MoD SLA I Wattisham Airfield

Application No. DC/22/04231

S96a Non-Material Amendment No. 2 – Summary Report

S96a Non-Material Amendment No.2 – Summary Report

Title
HARD LANDSCAPING PLAN-XX-G00400-XX

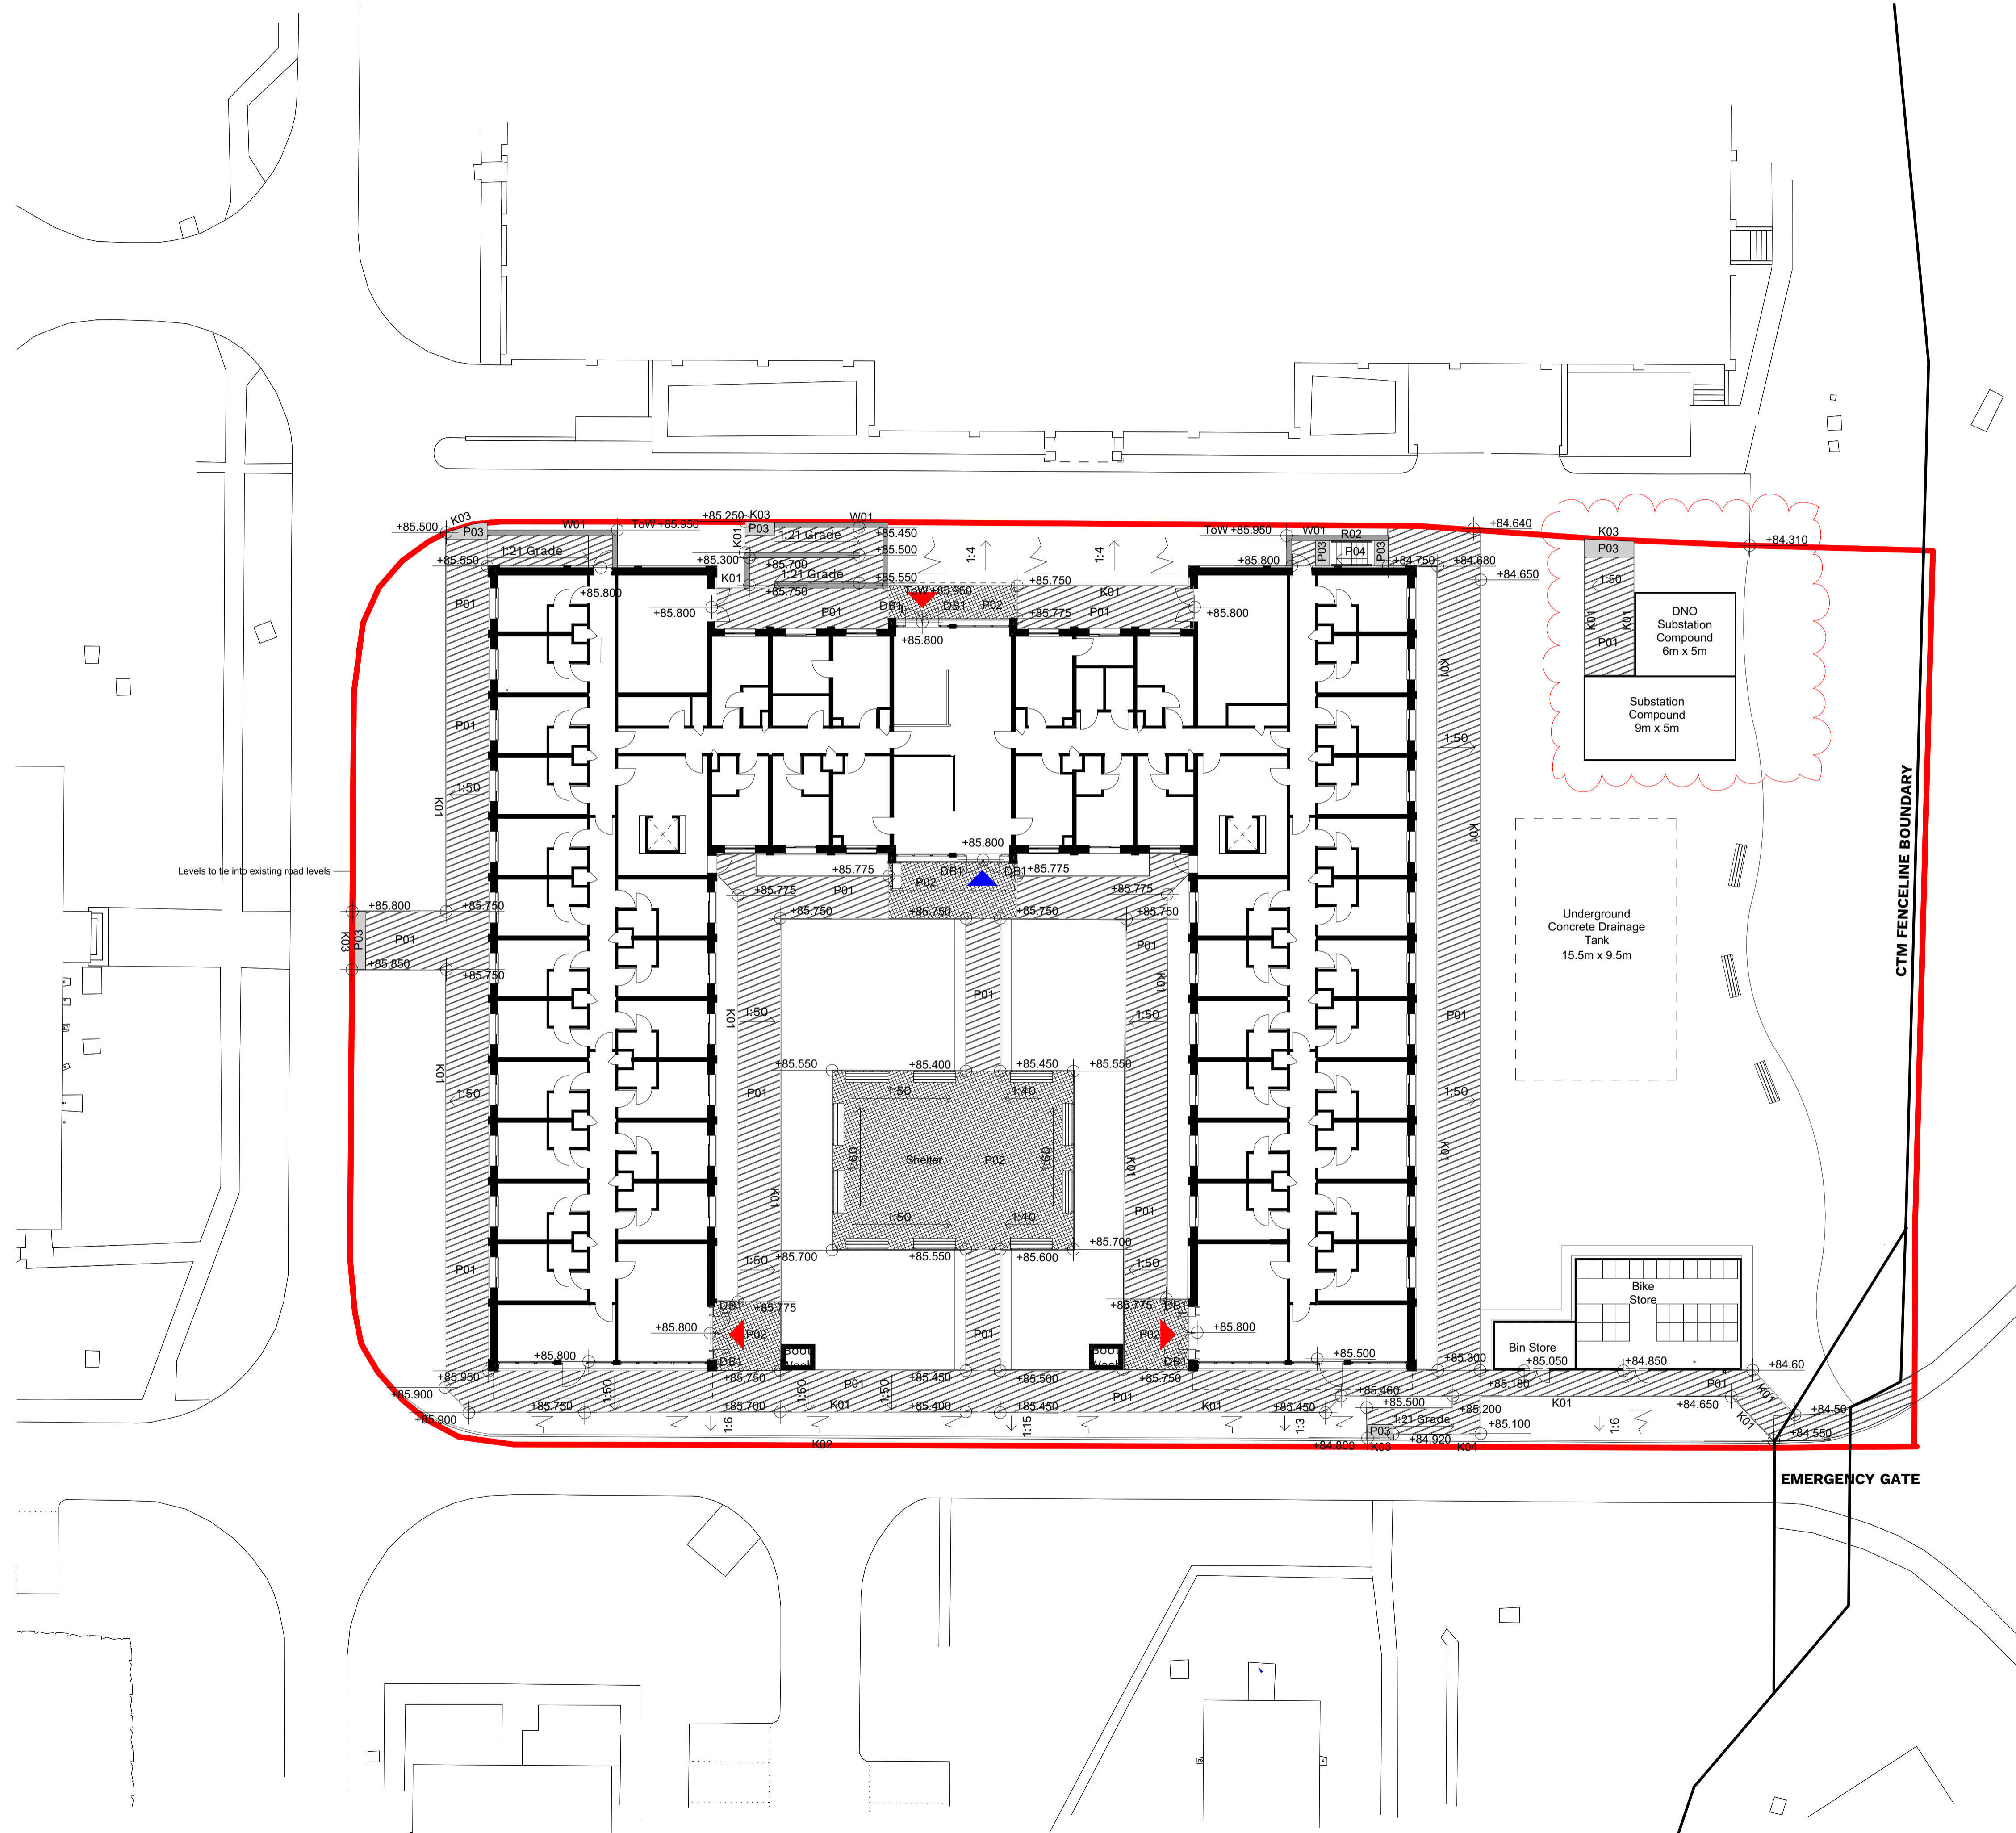
Reason for change : This is a new electrical substation compound housing a GRP substation but surrounded with a timber fence compound. The location indicated on the site plan is the preferred location due to existing services constraints adjacent the other localised sub stations.

Reason for change : Minor external amendments to layout – to reflect repositioning of ASHP to roof and new substation requirement.

Drawing: DRAINAGE DETAILS

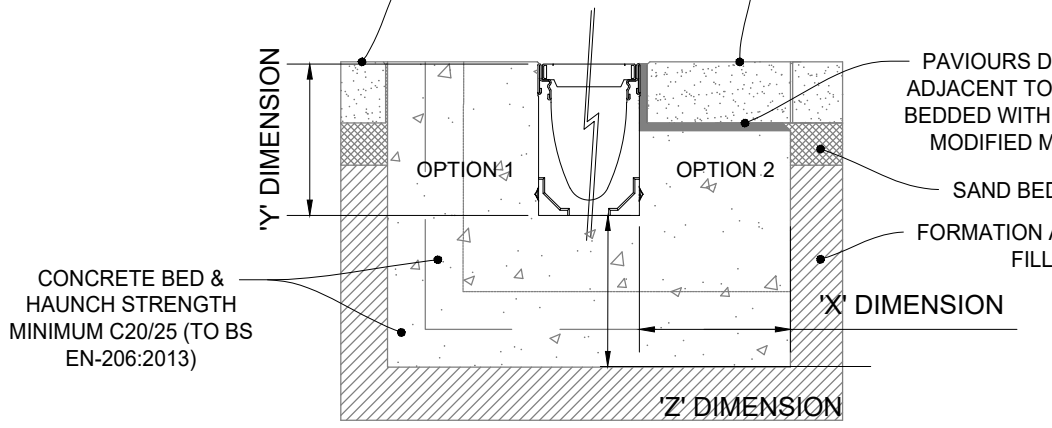
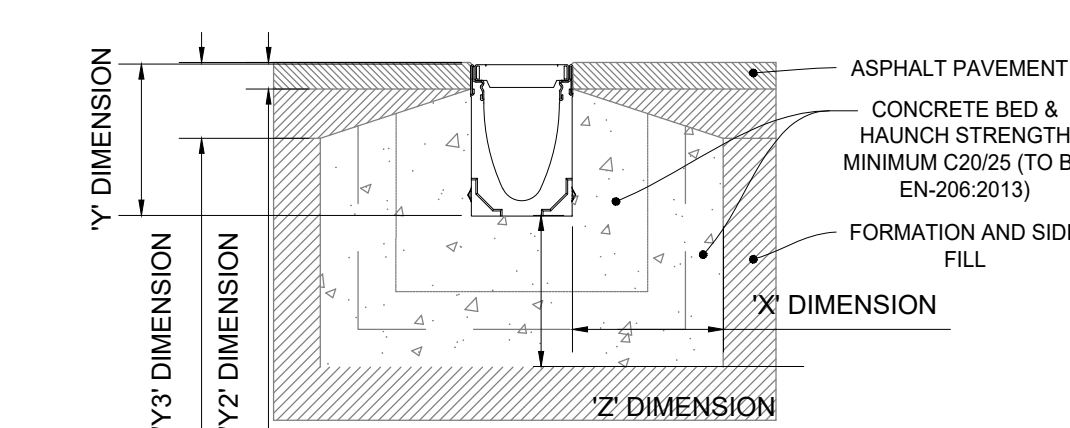
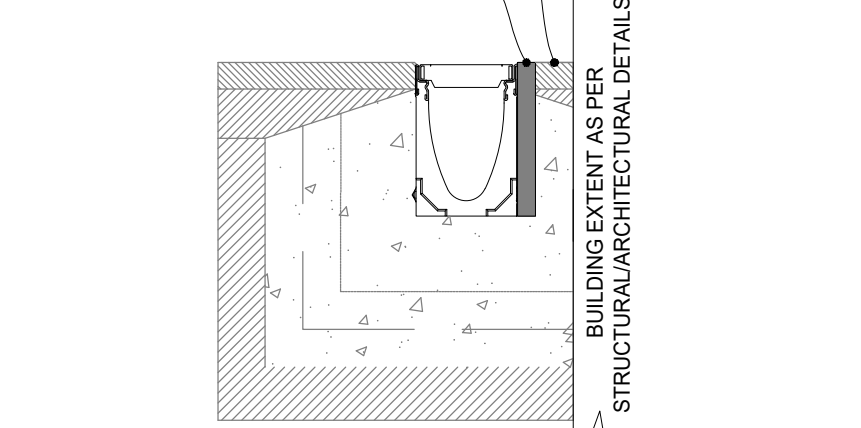
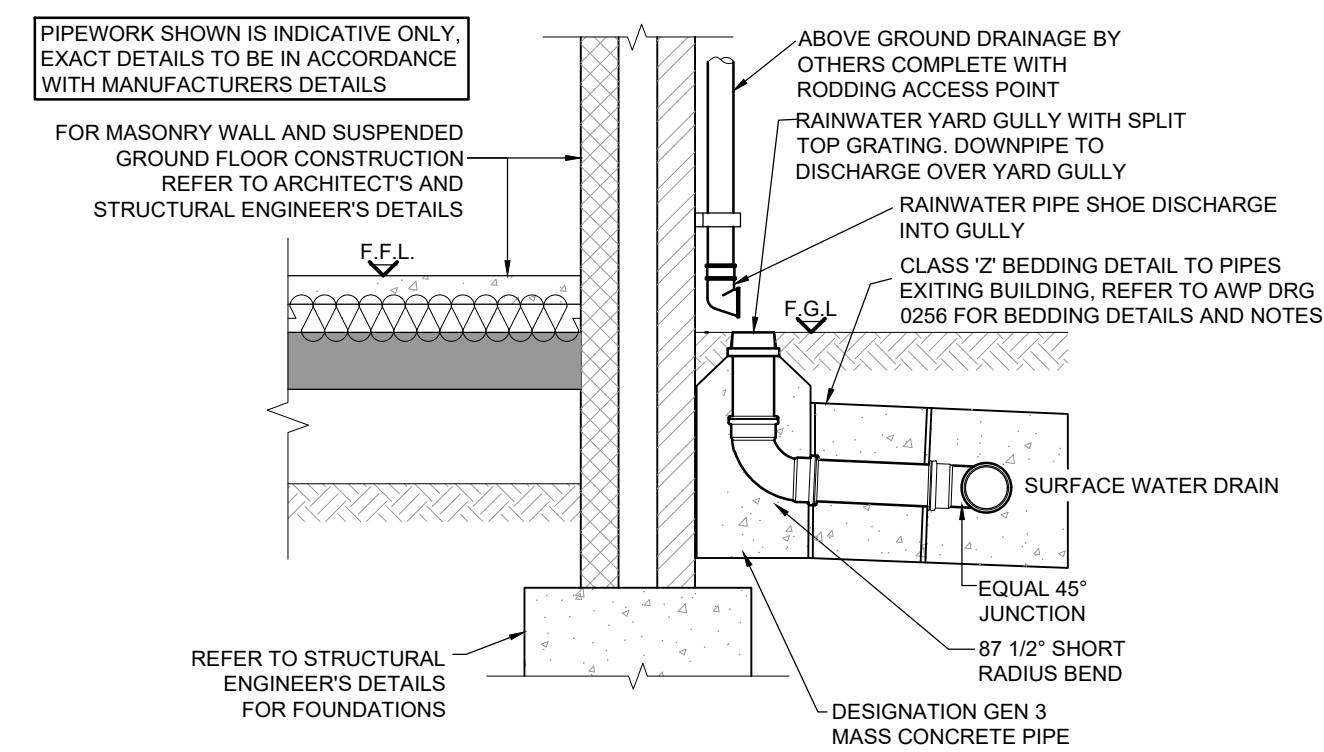
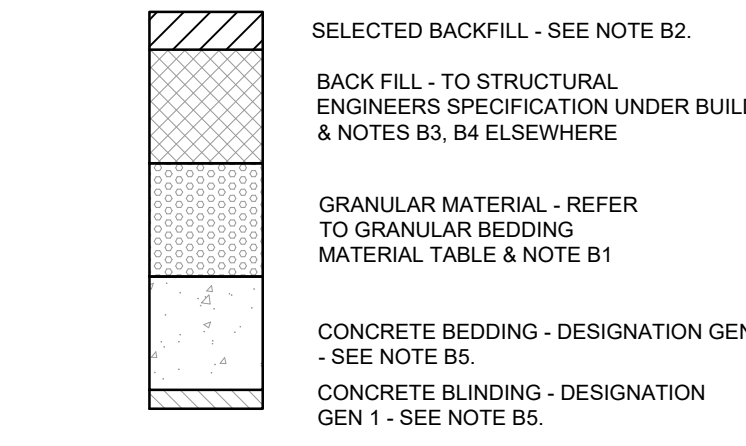
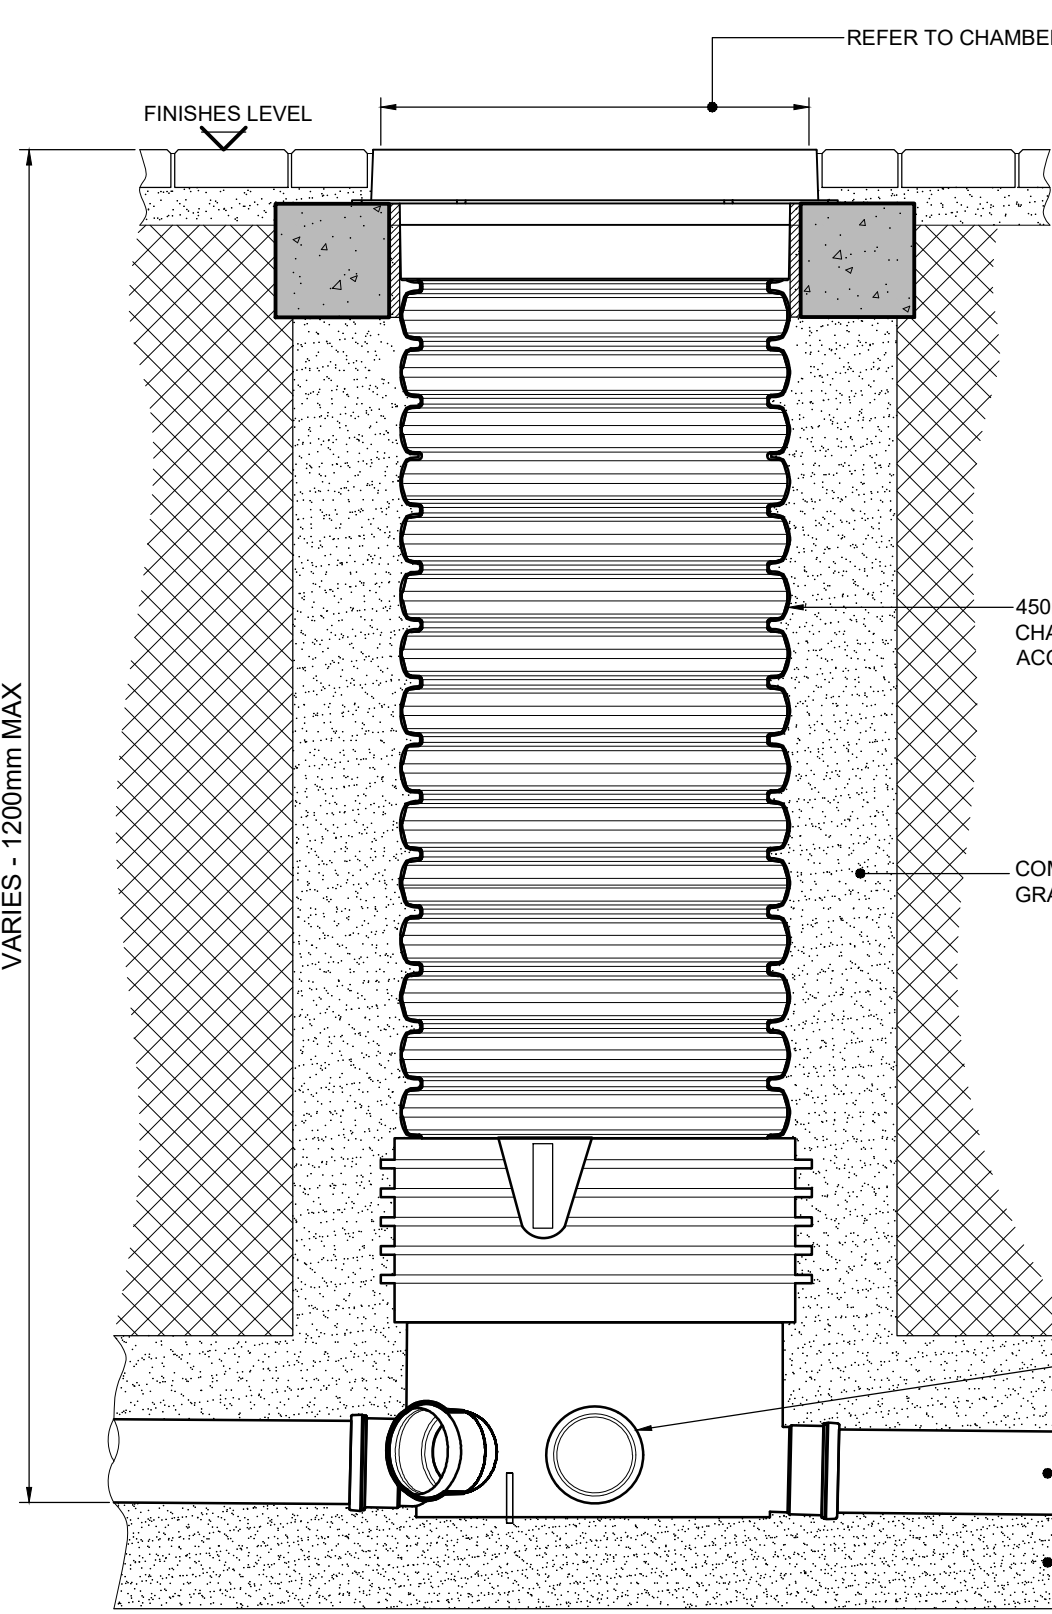
Reason for change : Variations to the drainage layout to suit unknown existing site services.

Title  
**BUILDING 1, GA ELEVATIONS SHEET 1 OF 3-XX-G00400-XX**

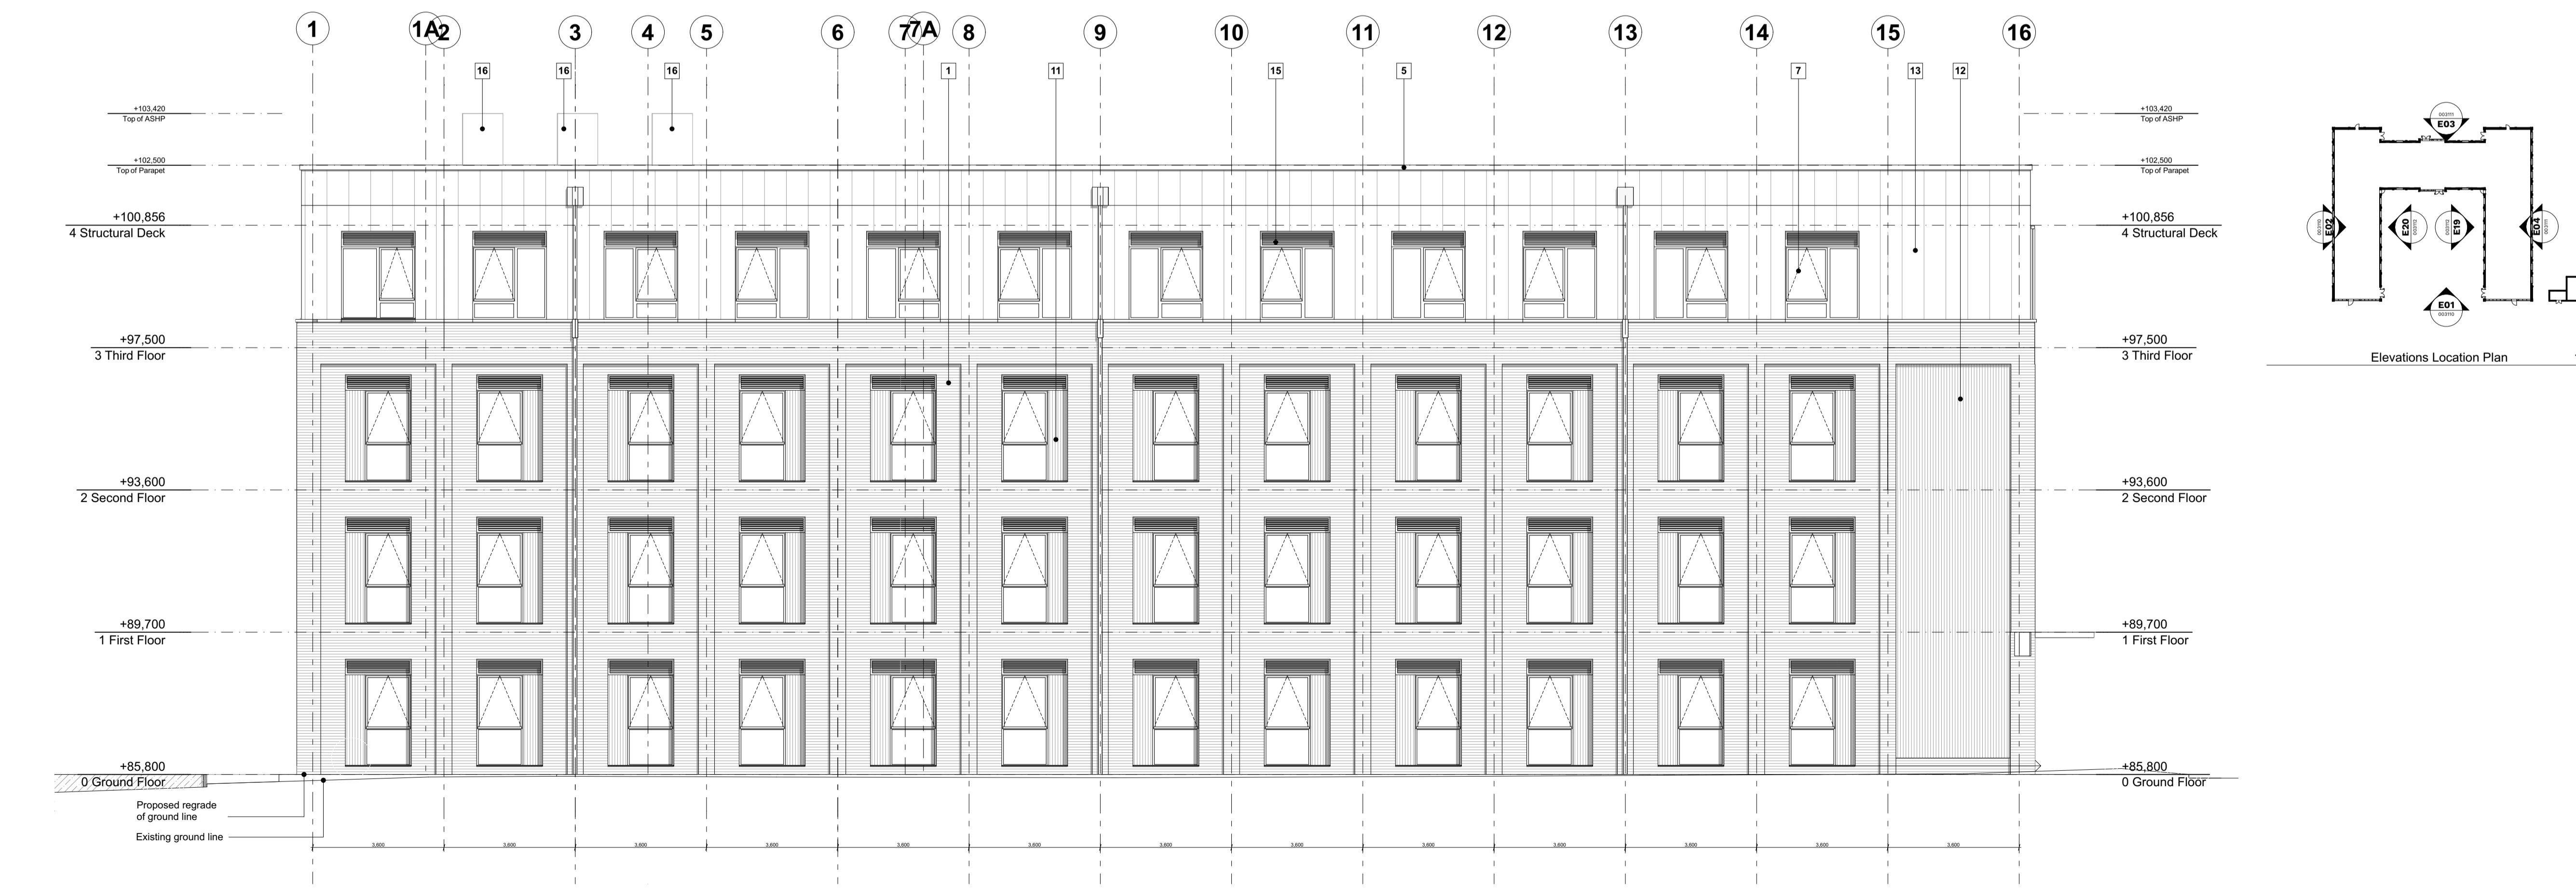
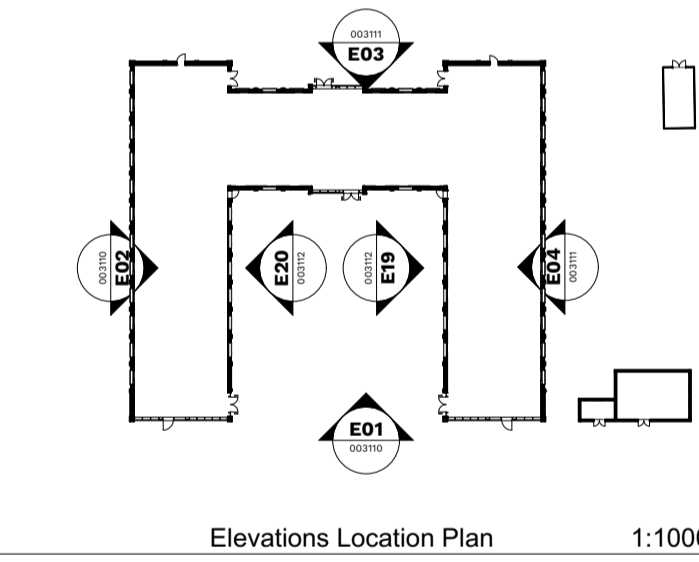
Reason for change : The required 6no. Air Source Heat Pump Units are proposed to be relocated on the roof of the SLA block. We are aware of the acoustic requirements and the technical details of the units have been supplied as below. The reasons for this change are listed below:

- Minimise visual impact -ASHP units are no longer overlooked by bedrooms and will be set-back behind an 1100mm high parapet.
- Reduced noise impact at roof level.
- No requirement for underground pipework so simpler coordination on site and installation
- No risk of underground pipework failure
- Reduced losses due to shorter pipework runs which will run vertically to the ground level plantrooms via service risers.
- The external area would be clear to locate the new substation and transformer – the location indicated on the site plan is the preferred location due to existing services constraints adjacent the other localised sub stations.
